Your ref: DA 024-05-2011
File No: MC-11-1124

16 June 2011

**Re: Exhibition of Development Application for Advertising Signage at
Blacktown Olympic Park, Doonside**

Premises: Lot 1, DP 1145826, 81 – 131 Eastern Road, Rooty Hill

PROPOSED
SIGNAGE LOCATION 3

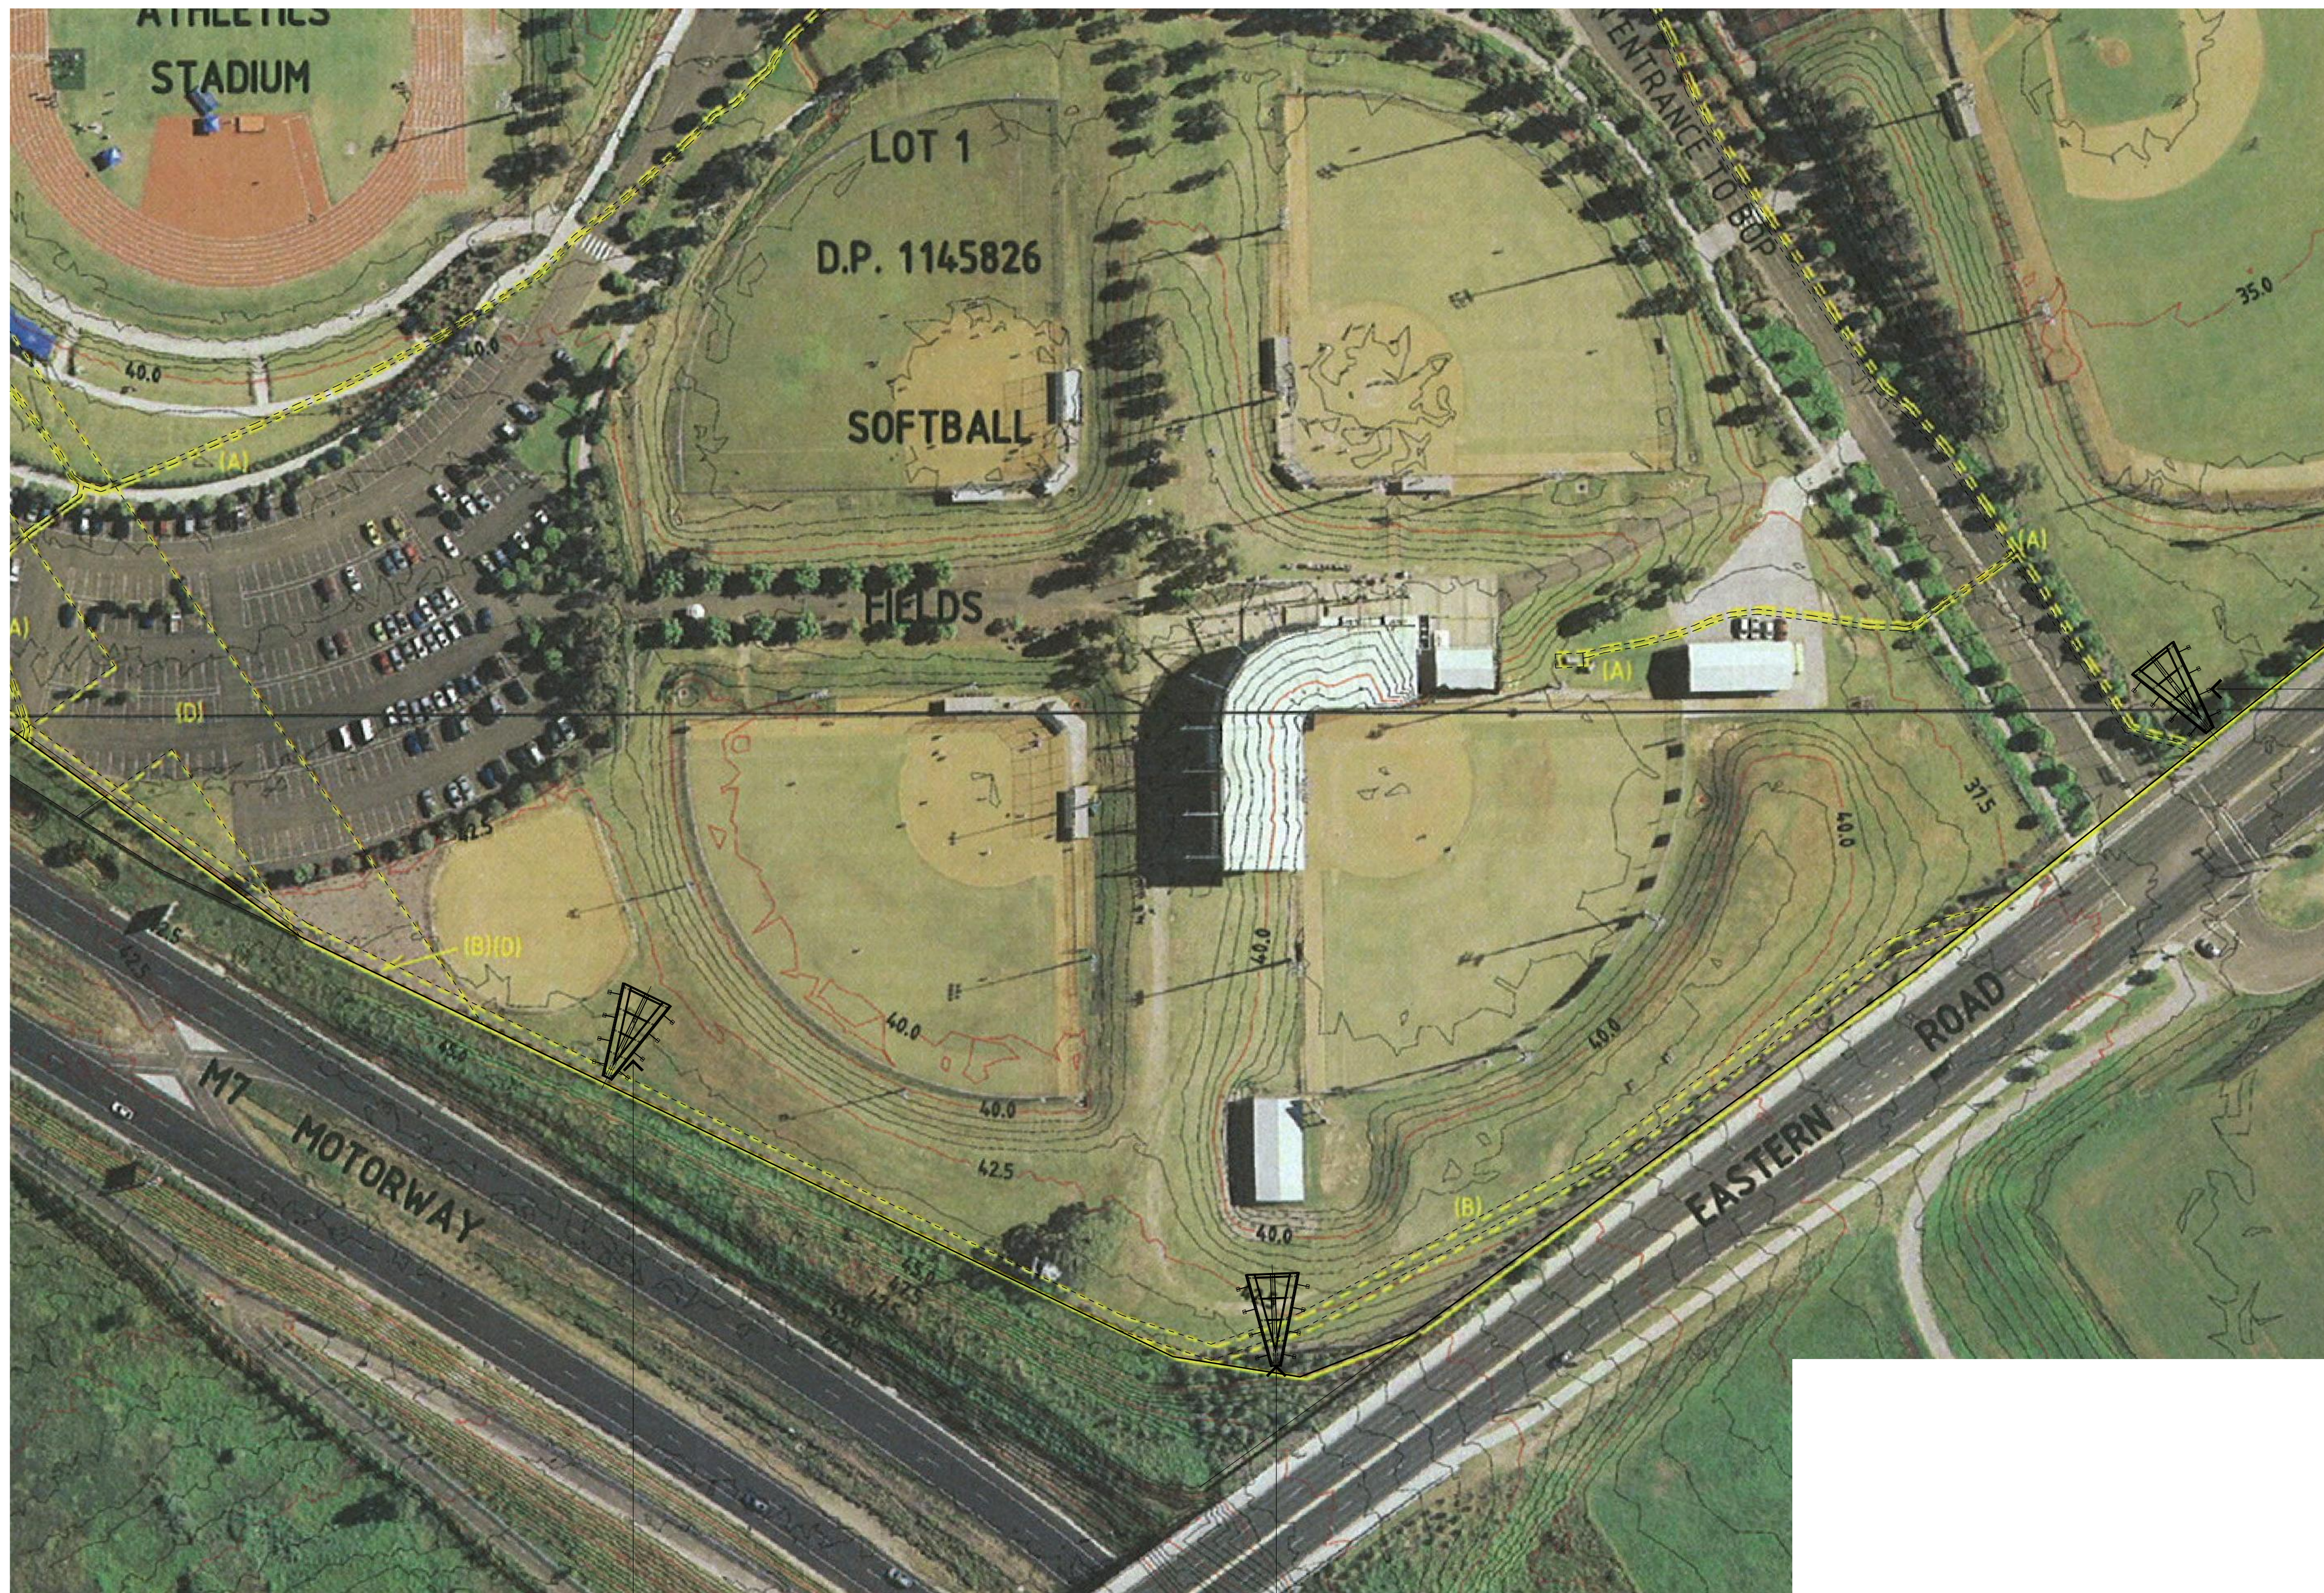
Signage no. 3 on the corner of Eastern Road and the main entrance to the Blacktown Olympic Park is to be moved into the site by at least 5 metres so as to not interfere with the traffic signals at the intersection.
